**KIRKLEES METROPOLITAN COUNCIL
INVESTMENT & REGENERATION SERVICE**

**DELEGATED DECISION FOR APPLICATION FOR CERTIFICATE OF
LAWFUL DEVELOPMENT**

Reference no.: 2025/CL/91489/W

Site: 402, Bradley Road, Bradley, Huddersfield, HD2
1PS

Proposed Ground Floor Plan
1:50

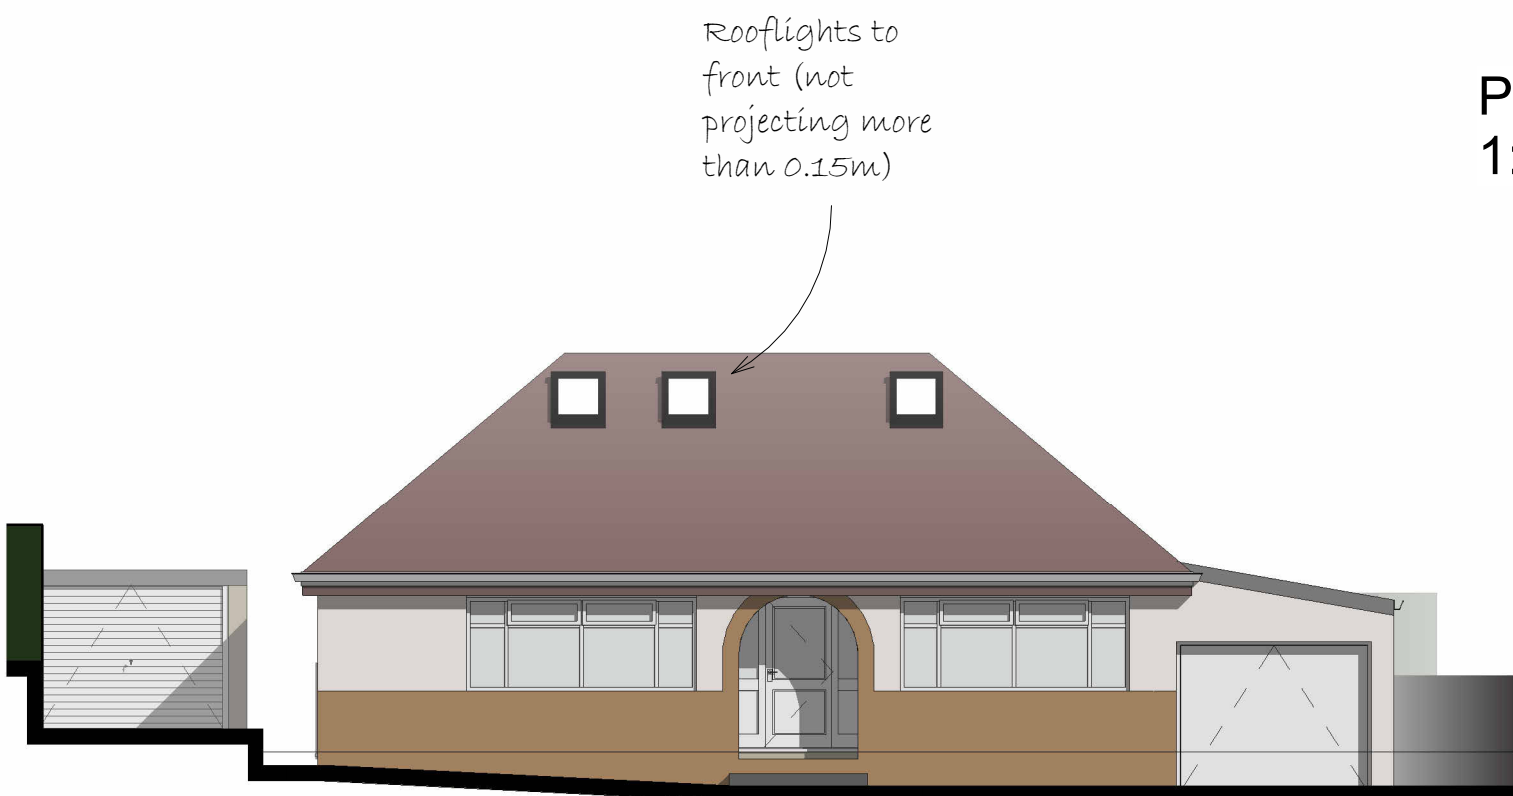
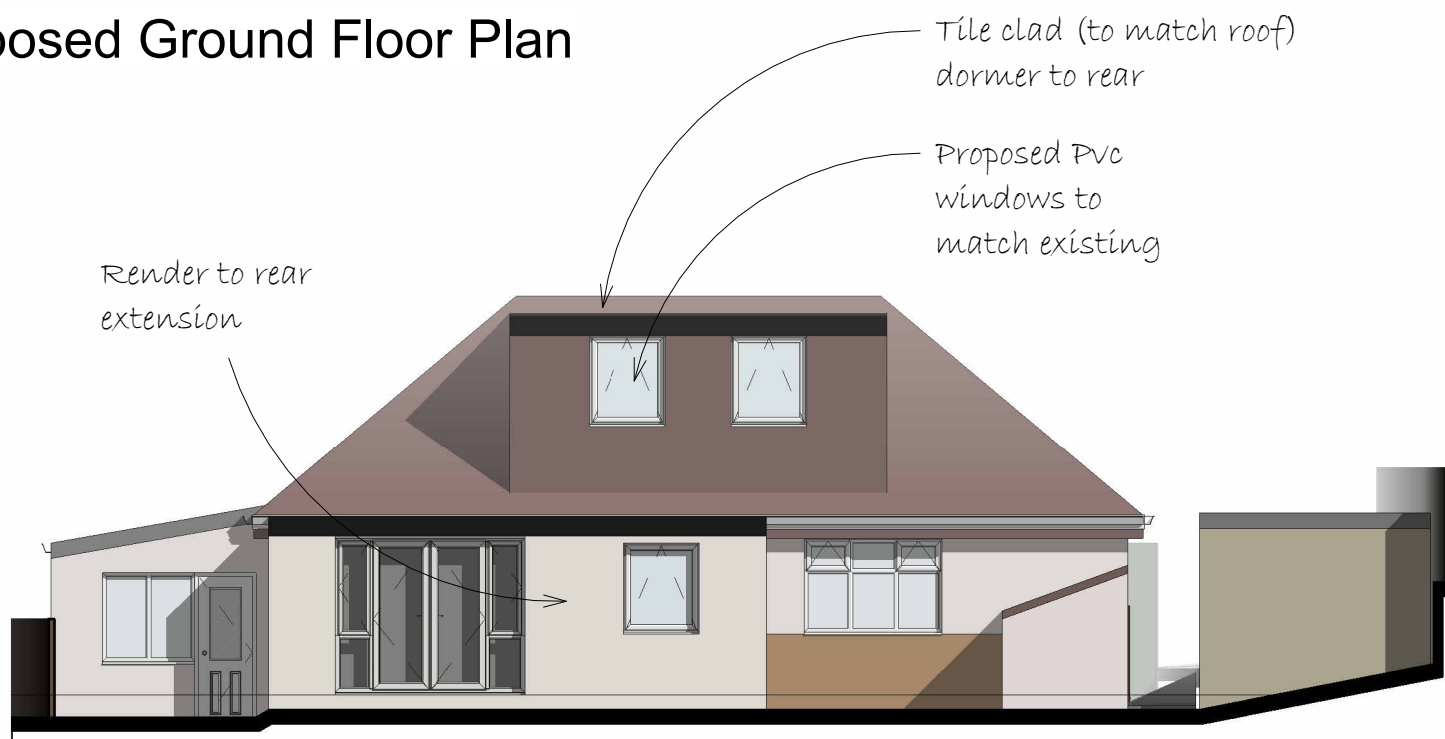
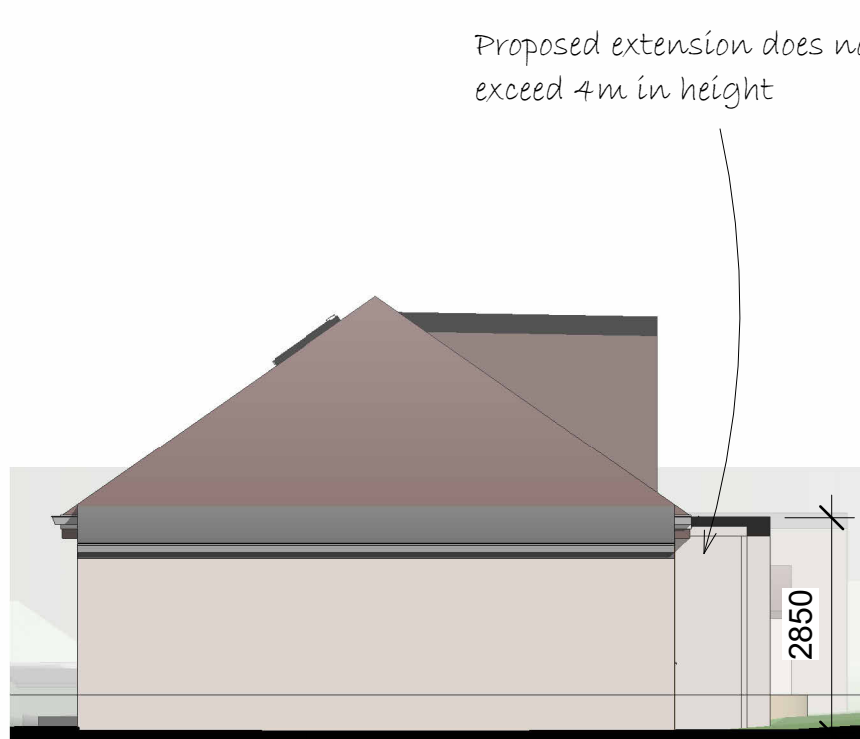
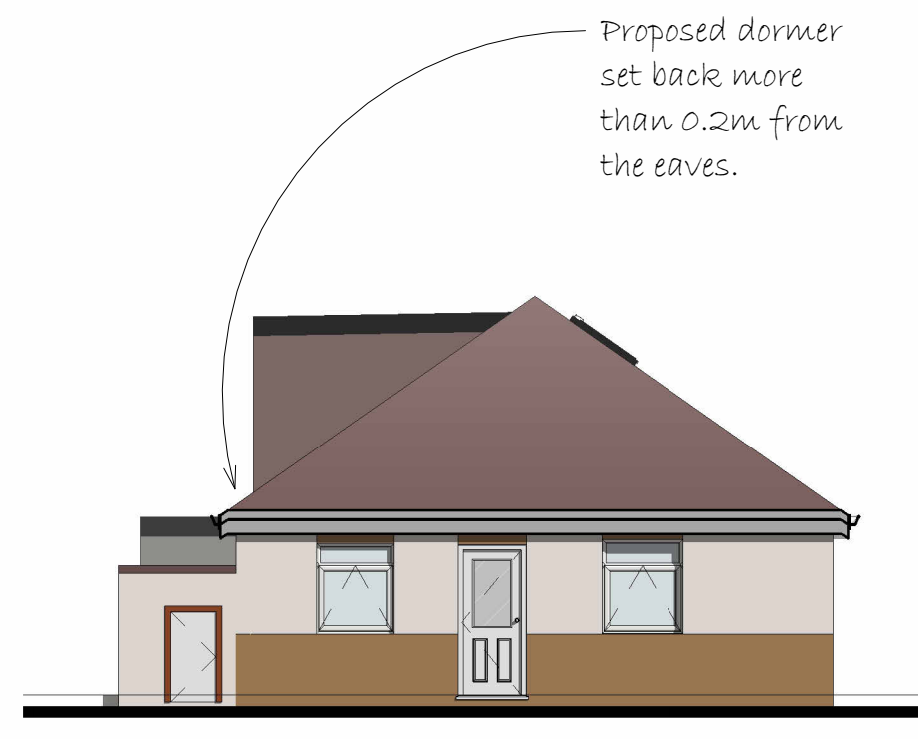
Comment: *The existing plans demonstrate that 2 no. chimneys are located on the ridge of the existing roof form. The proposed attic floor plan (drawing number 2025126-102) clearly annotate that the chimneys would be demolished and therefore an alteration to a chimney. This would constitute an alteration of a chimney and therefore would fall within Part 1, Class G of the Act (as amended) and shall be assessed as part of this report.*

Comment: *The existing plans demonstrate that 2 no. chimneys are located on the ridge of the existing roof form. The proposed attic floor plan (drawing number 2025126-102) clearly annotate that the chimneys would be demolished*

and therefore an alteration to a chimney. This would constitute an alteration of a chimney and therefore would fall within Part 1, Class G of the Act (as amended) and shall be assessed as part of this report.
